**KIRKLEES METROPOLITAN COUNCIL
INVESTMENT & REGENERATION SERVICE**

DELEGATED DECISION TO DETERMINE PLANNING APPLICATIONS

Reference No:	2025/62/91642/W
Site Address:	336, Scar Lane, Golcar, Huddersfield, HD7 4AR
Description:	Formation of vehicular access, excavation works to front garden, erection of retaining walls and front steps (within a Conservation Area)
Recommending Officer:	Molly Storer

DECISION - REFUSE

336 Scarbawne, Huddersfield, golcar HD74 AR

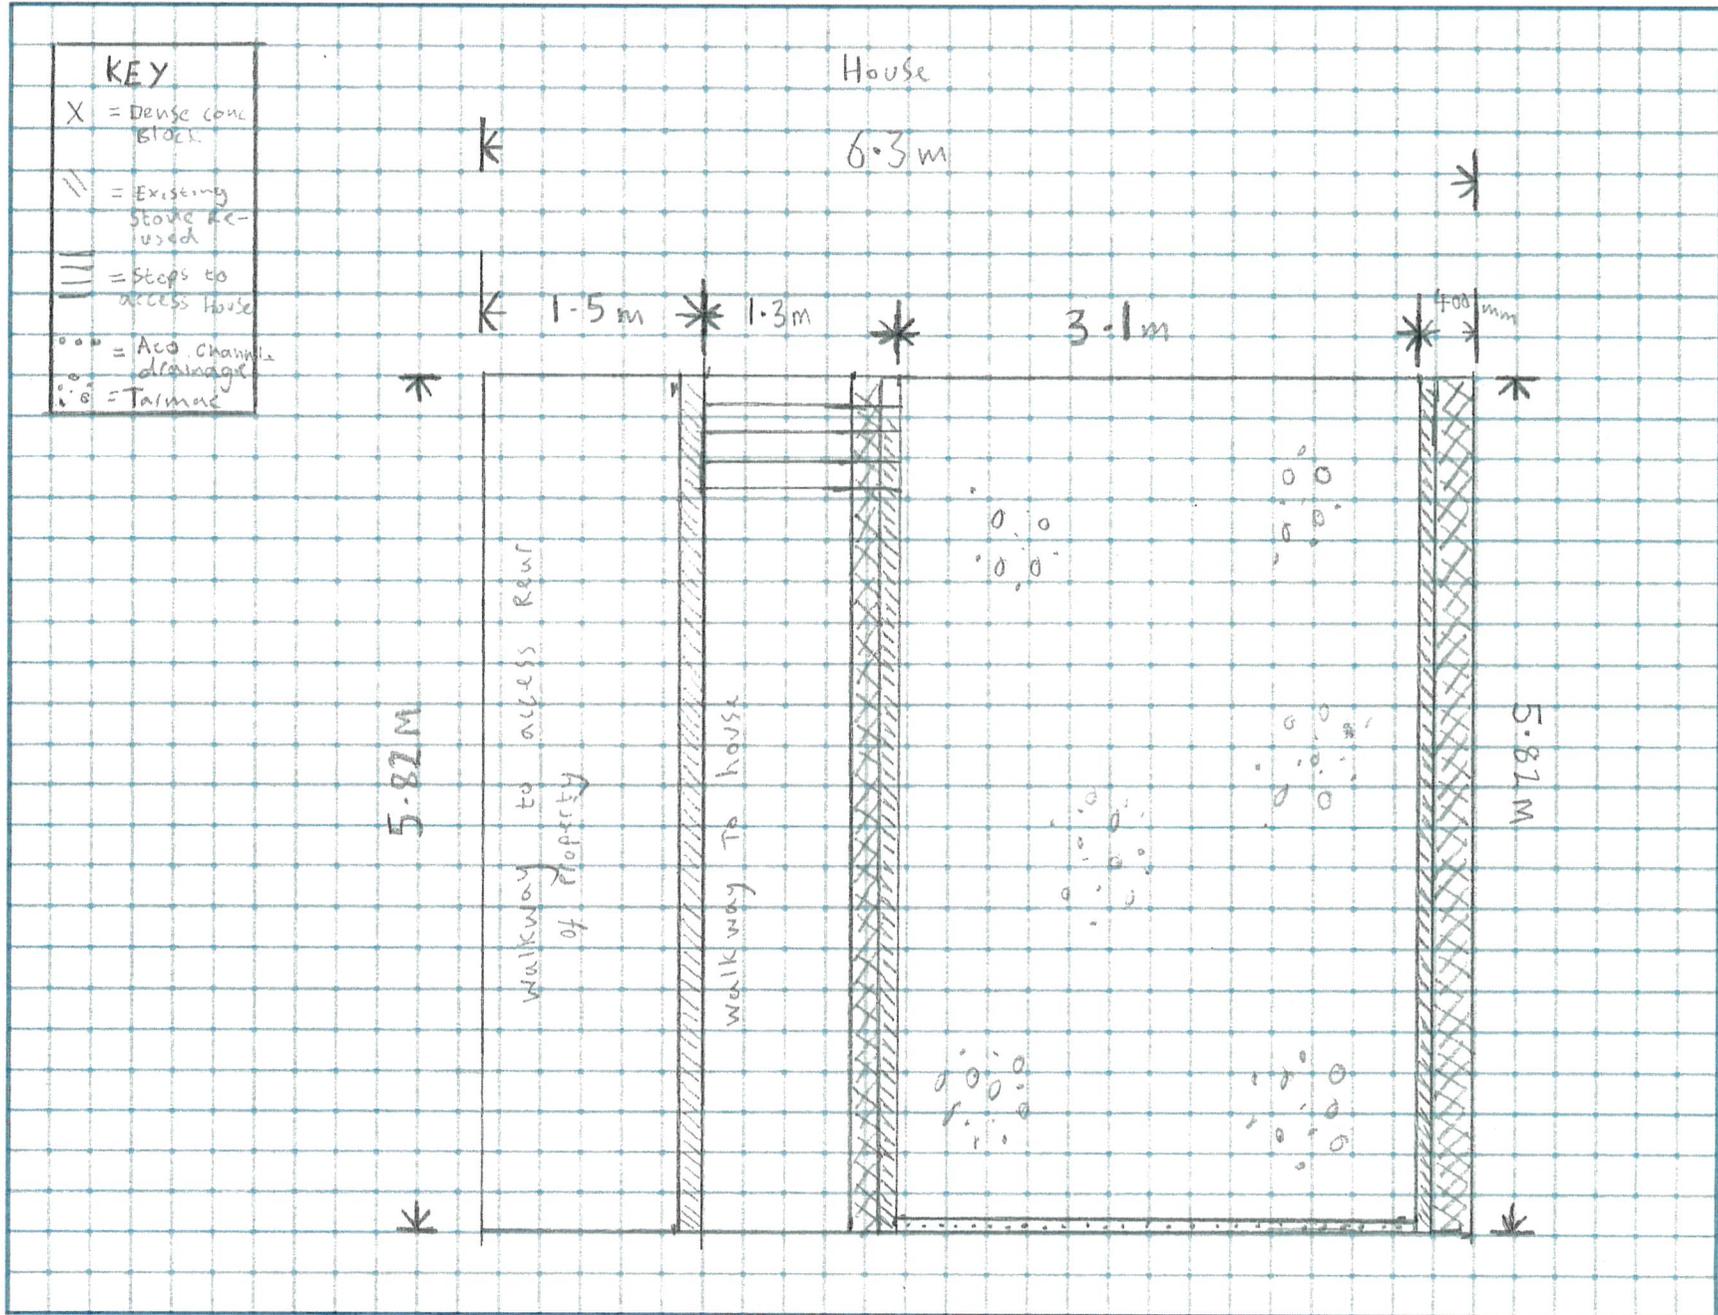
The proposal is for vehicular access and the regrading of a front garden to provide a car parking space. The parking would occupy a large majority of the front garden. The other three terraces have not regraded their front gardens to provide parking or driveways, meaning this development would be the first of its kind on the row of terraces.

The proposal to remove the natural stone coursed wall and coping at the front of 336 Scar Lane, and the reduction of the land levels would not preserve or enhance the Conservation Area and would make a negative contribution. This would be classed as less than substantial harm of a moderate level that would not be outweighed by public benefits. Whilst the scheme would provide one off-street parking space this is not considered to outweigh the harm to the Conservation Area.

It is therefore concluded that by virtue of its design the proposed development would have a detrimental visual impact within the street that would not harmonise with the established character of the traditional row of terraces and have a harmful visual impact upon the host property as well as the character of the Conservation Area. The proposal would lead to less than substantial harm to the significance of the Golcar Conservation Area whereby public benefit of the scheme would not outweigh this harm, contrary to Policy LP35 and Policy LP24 (a and c) of the Kirklees Local Plan, Principles 1 and 2 of the Kirklees

336 Scar Lane, Golcar, Huddersfield
HD7 4NR Cross Section

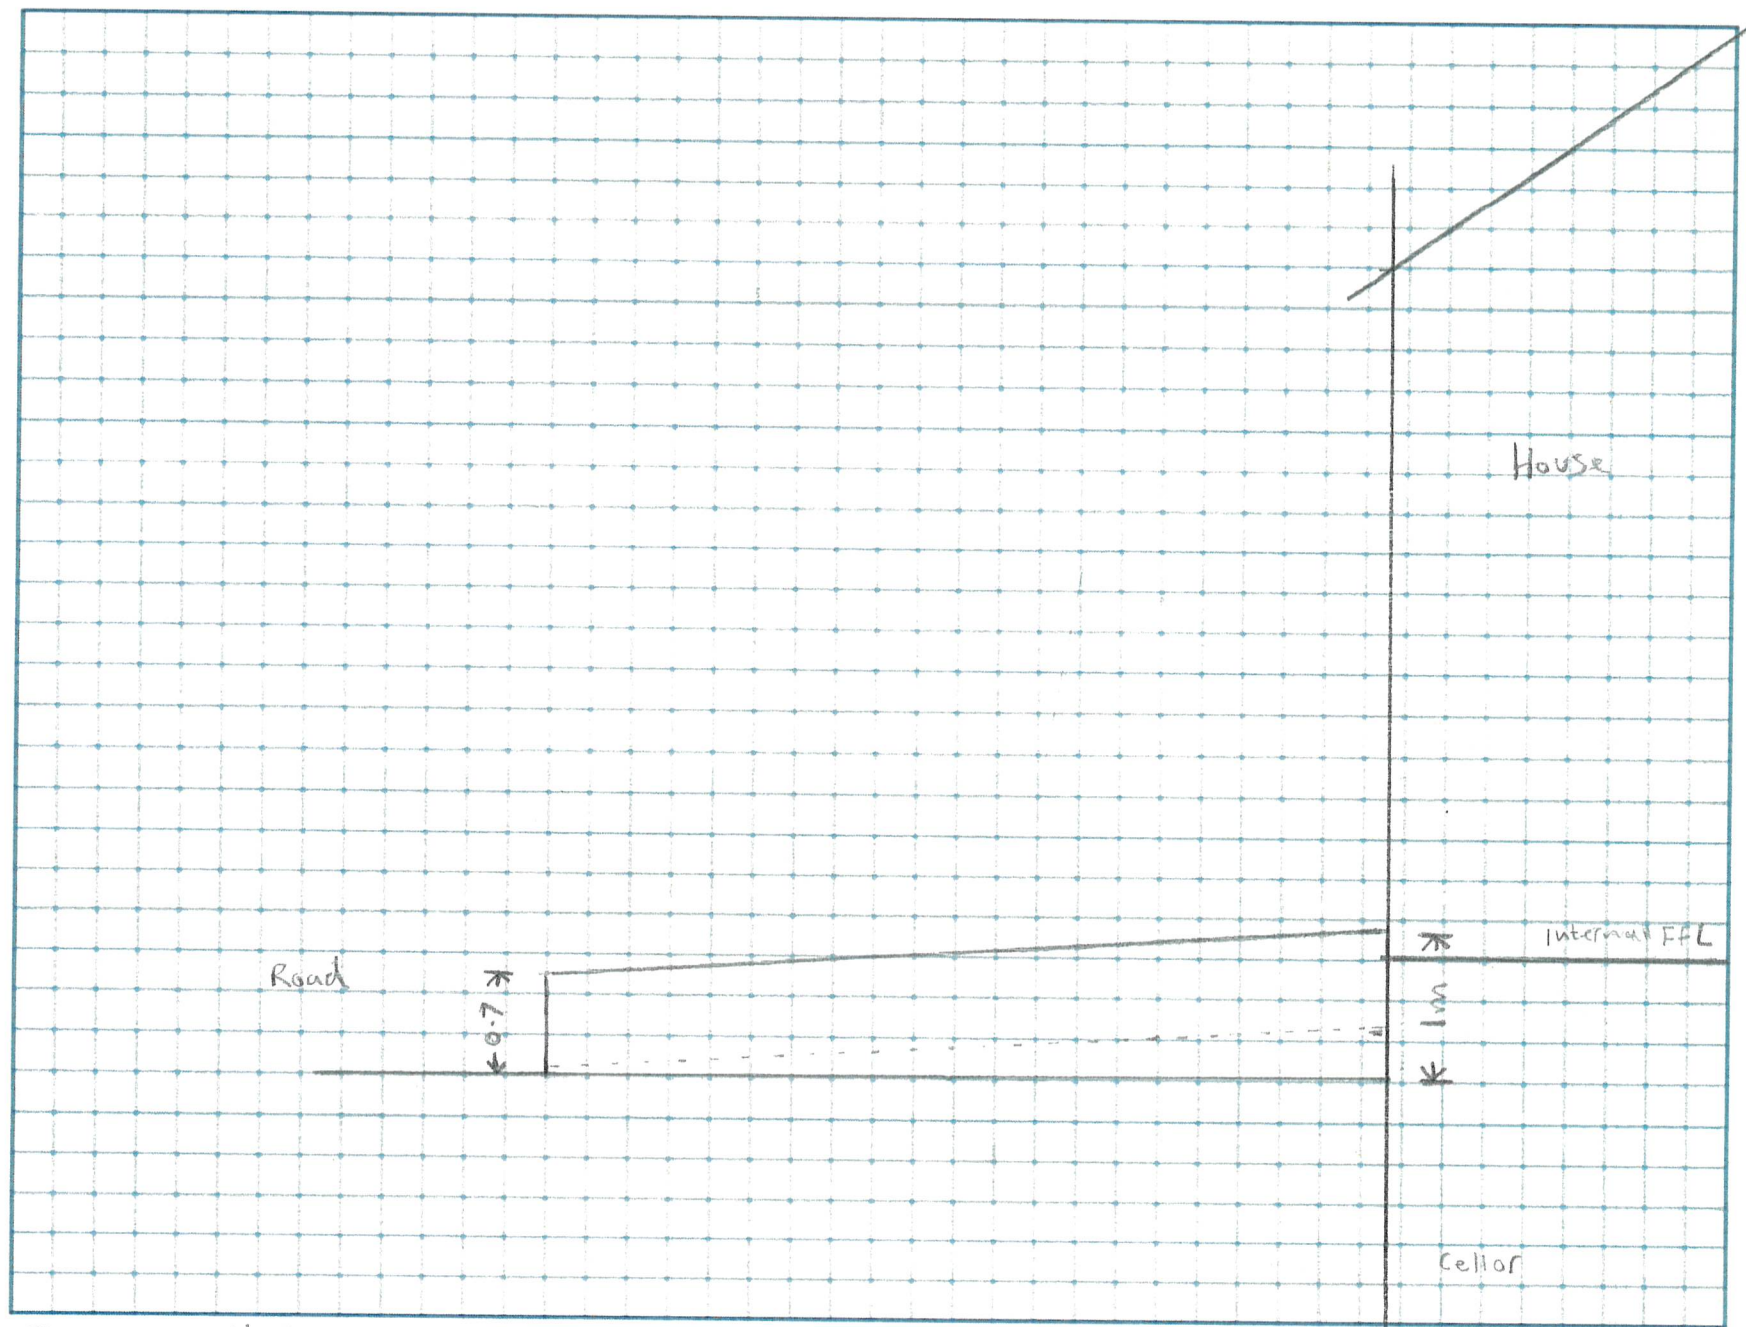
In terms of visual amenity although properties on the opposite side of the road have created driveways and vehicular access, this is established on this side of the road and due to the topography and the properties being accessed at the road level this required less excavation works. It is considered that the formation of a driveway would appear out of place and disrupt the harmony of the street scene on this side of the road.
